## TOWN AND COUNTRY PLANNING ACT 1990 FULL

**Reference:** H09-1278-25 **Date of Decision:** 27th February 2026  
**Applicant:** Loosegate Developments Ltd  
C/O Lincs Design Consultancy  
12 Vickers Lane  
Louth  
Lincolnshire  
LN11 9PJ  
**Location:** Land East Of Forest Way Holbeach Spalding Lincolnshire  
**Description:** Proposed Erection of 2 Bungalows

DRAWING NUMBER : LDC4657 - 10

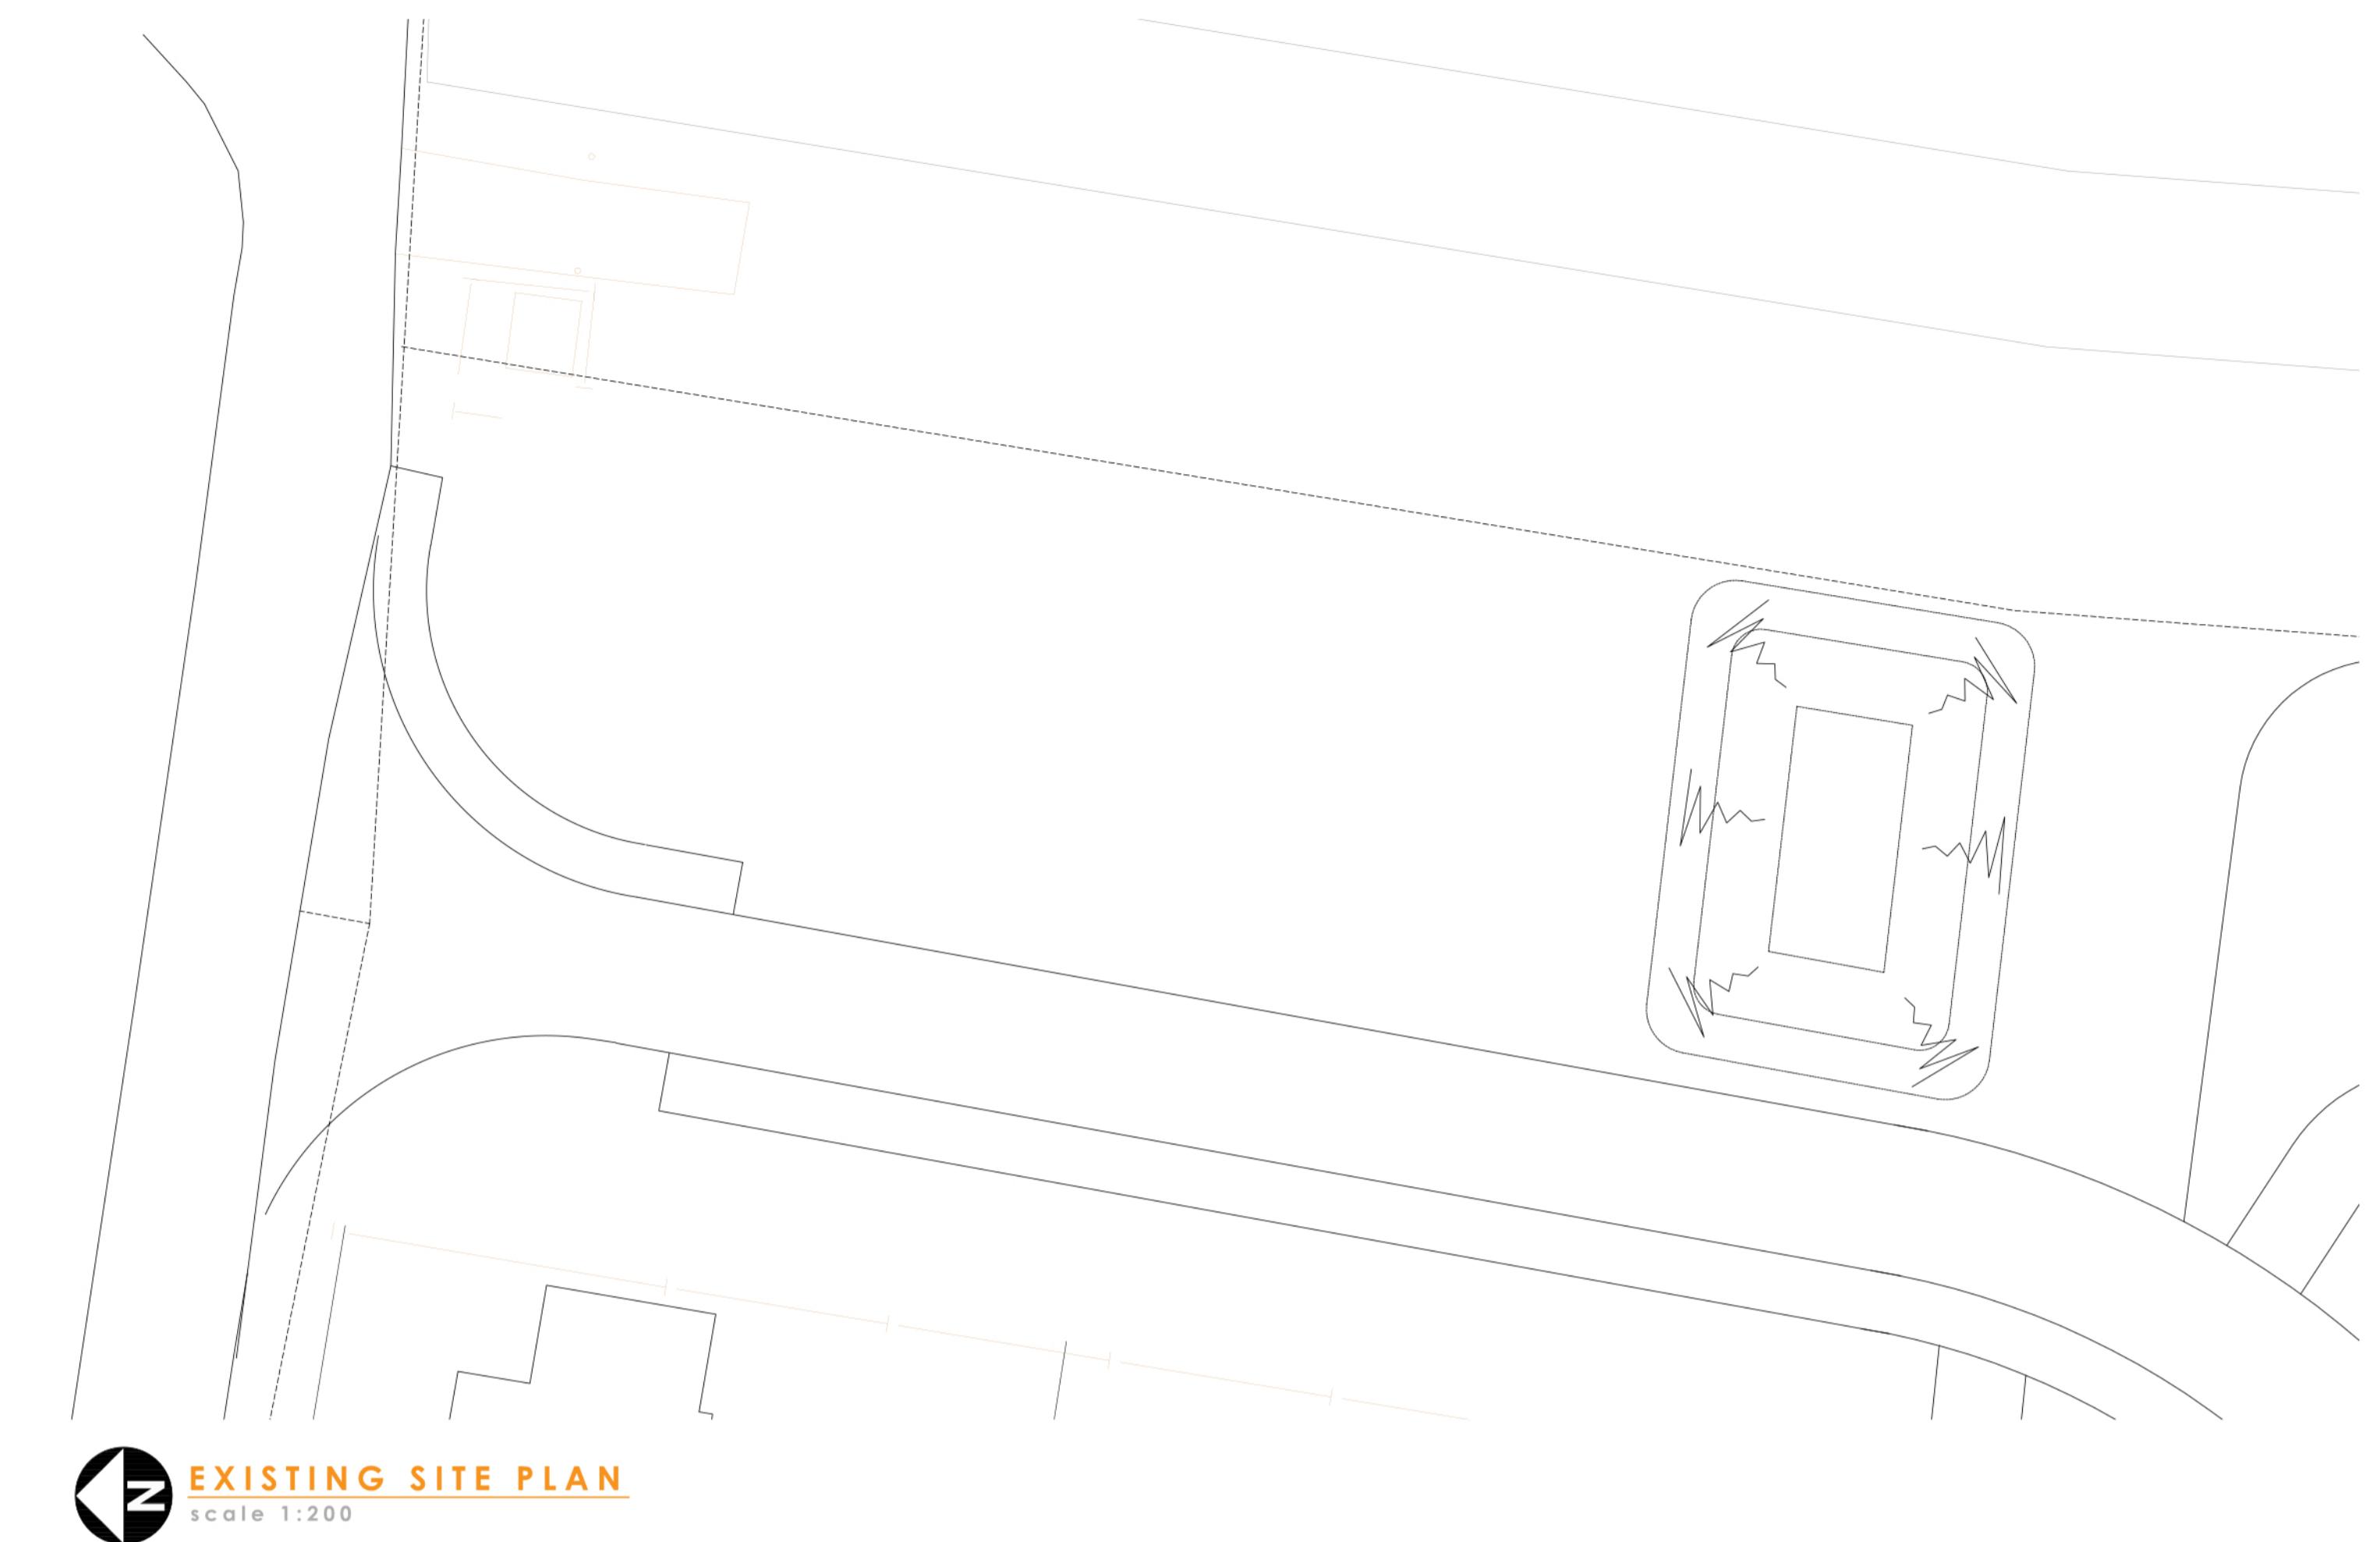
- 1 The proposed development represents an incongruous and cramped form of development due to the proposed siting of the dwellings within the site. The proposal represents an overdevelopment of the site which would be out of keeping with the locality, character and appearance of the area, including the surrounding built environment. This would result in an unacceptable impact on the character and appearance of the area.

- 2 The proposal would result in an unacceptable degree of outlook from the proposed bungalows due to the proposed positioning of 1.8m high timber fencing approximately 1 metre from the rear elevation of the bungalows. This fencing would block most of the outlook from the rear windows of the bungalows, resulting in an unacceptable impact on the amenity of future occupants.
